DRB CASE ACTION LOG - BLUE SHEET

Project #: 1009090 Application #: 13DRB-70589  
Project Name: \_\_\_\_\_  
Agent: Tiora West LLC Phone #: \_\_\_\_\_

**Project# 1009090**  
13DRB-70407 VACATION OF PUBLIC RIGHT-OF-WAY

TIERRA WEST LLC, agents for CAPSTONE HOUSING request the referenced/ above action for the southern portion of **MULBERRY ST SE** and the remaining portion of **BETHEL AVE SE** located east of **INTERSTATE 25** and south of **GIBSON BLVD SE**.  
(M-15)

CONDITION OF FUTURE PHASE 3
 A DESIGN VARIANCE (LENGTH OF STUB STREET) IS REQUIRED TO VACATE A PORTION OF MULBERRY STREET AS SHOWN ON THE SITE PLAN. IF THIS VARIANCE IS NOT APPROVED, A TURNAROUND MUST BE PROVIDED.

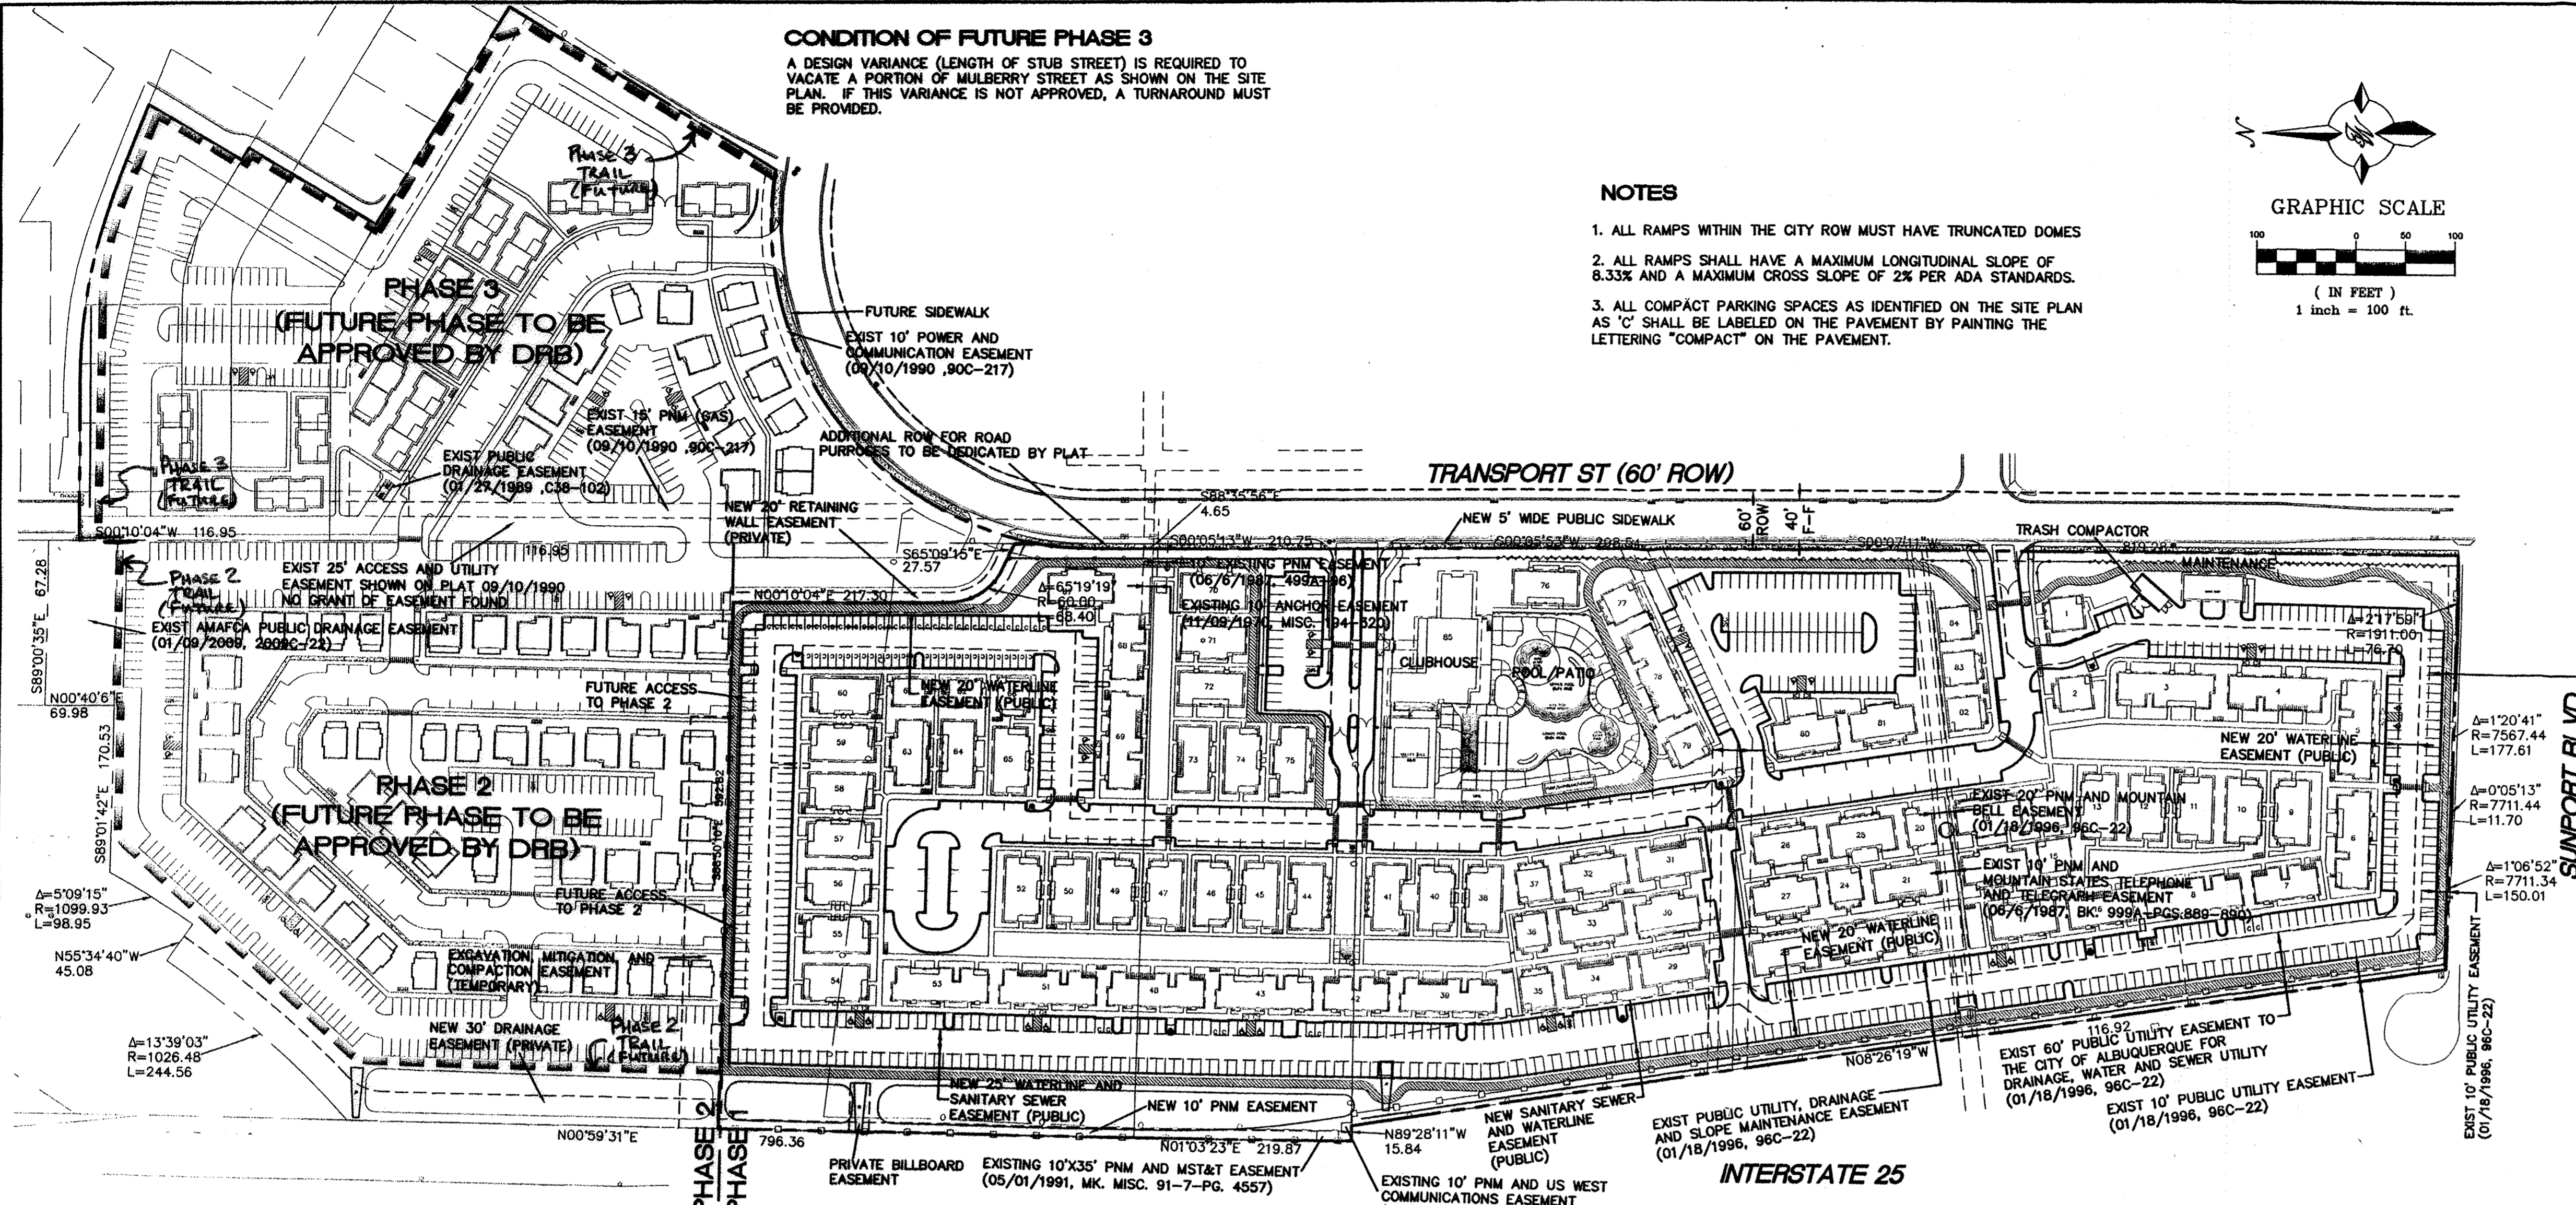
Does Mulberry Street meet the criteria for a stub street (maximum number of units is 4 and the maximum length is 150' measured from the centerline of the intersecting street to the end of the stub street)?
